Vattenfall Wind Power Ltd

Thanet Extension Offshore Wind Farm

Annex A to Appendix 1 to Deadline 5 Submission:
Response to ExAQ2.1.8a

Date: April 2019

Figure A 10 Contour plot showing the TTS impact ranges for species of fish (Popper et al., 2014) for both modelling locations for both monopile and pin pile scenarios

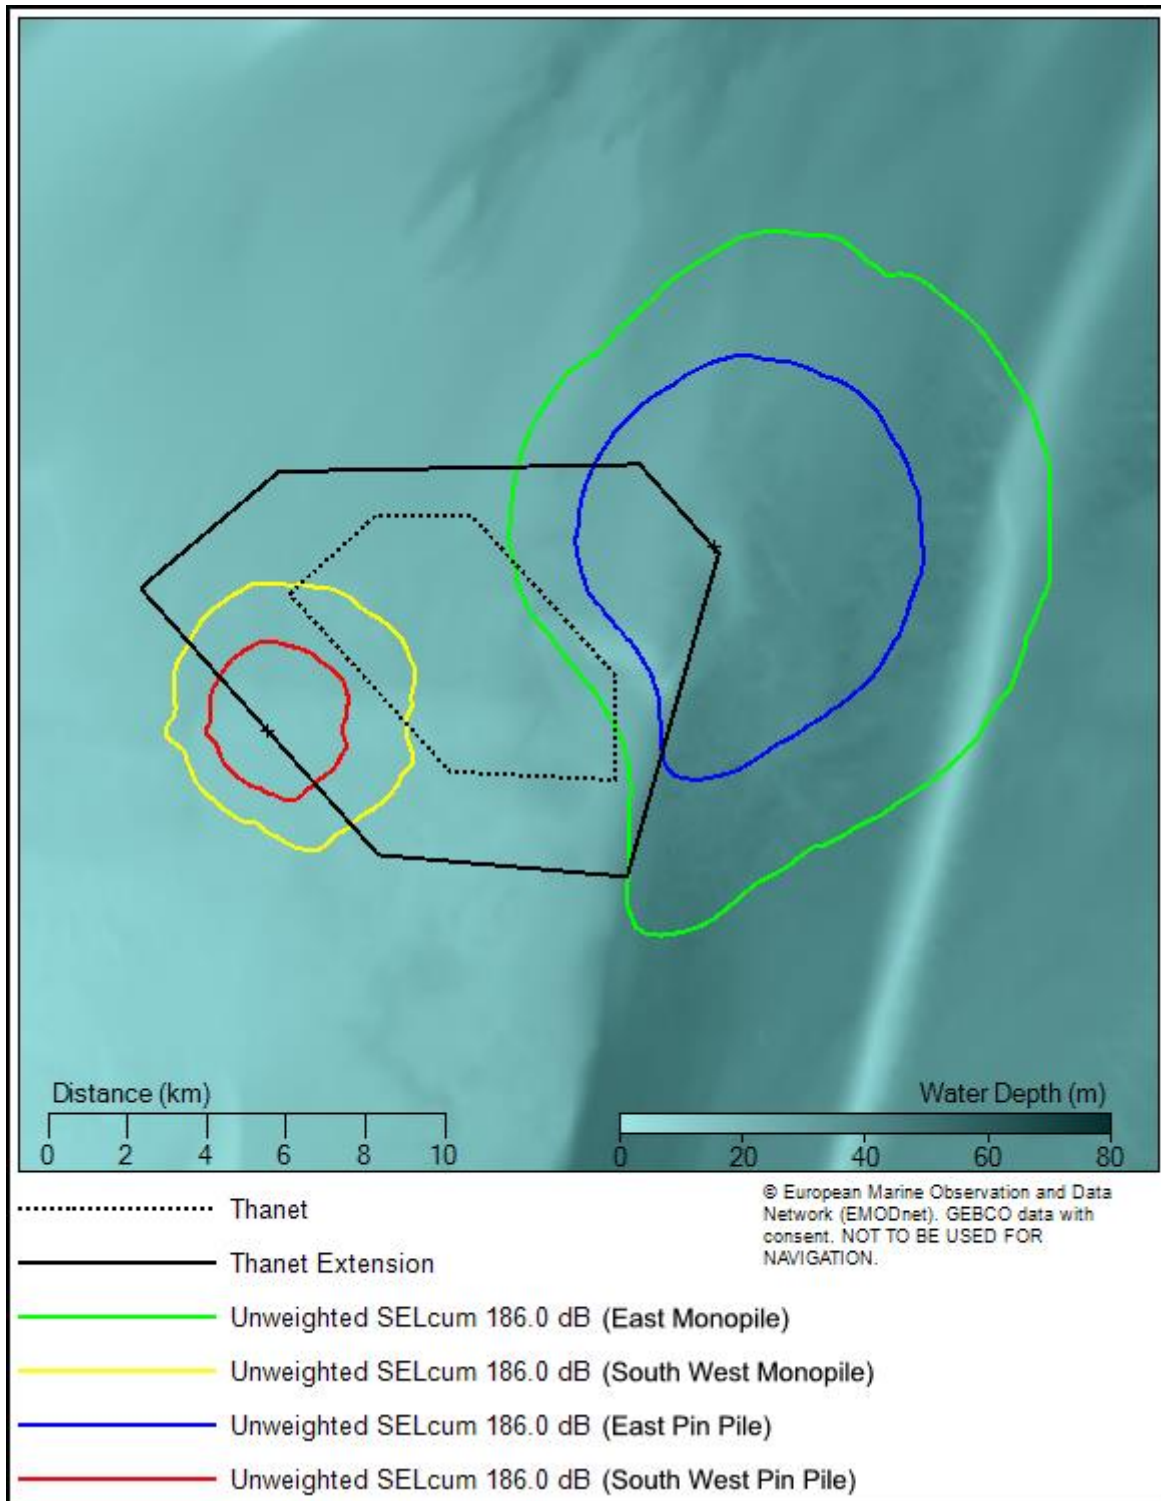
1.2.6	<p>The MMO therefore does not agree that additional modelling will be inconsequential.</p>	
1.2.7	<p>Consequently, the MMO is concerned that the current modelling is not sufficient to fully assess the potential impact on herring spawning areas. Figure 6-14 shows an overlay of the 186 dB re 1 μPa_{2s} SELcum (TTS threshold) noise contours along with herring spawning areas. This figure demonstrates that there is partial overlap between the TTS range and herring spawning grounds (to the East of the site, where IHLS survey data indicates herring larval abundance of between 27,700-50,100 per m²), however this area of overlap is small in the context of the wider habitat available (para 6.10.51). The predicted impact ranges for SELcum, if based on a stationary receptor, may be larger than this, and may extend into the Herne Bay and/or Eastern channel spawning grounds. However without the</p>	<p>Please see previous responses and the Appendix 7 of the Applicant's Deadline 4c Submission, which presents stationary receptor modelling.</p>

Point	Text	Applicant's Response
	<p>grounds in the Greater Thames Estuary and whether it extends into known areas of higher spawning intensity. The Applicant's Environmental Statement (ES) presented an overlay of the 186 dB re 1µPa2s SELcum (TTS threshold) noise contours along with only herring spawning areas (ES Figure 6-14). The noise contours have not been overlaid onto identified sole spawning grounds (refer to ES Figure 6-4).</p>
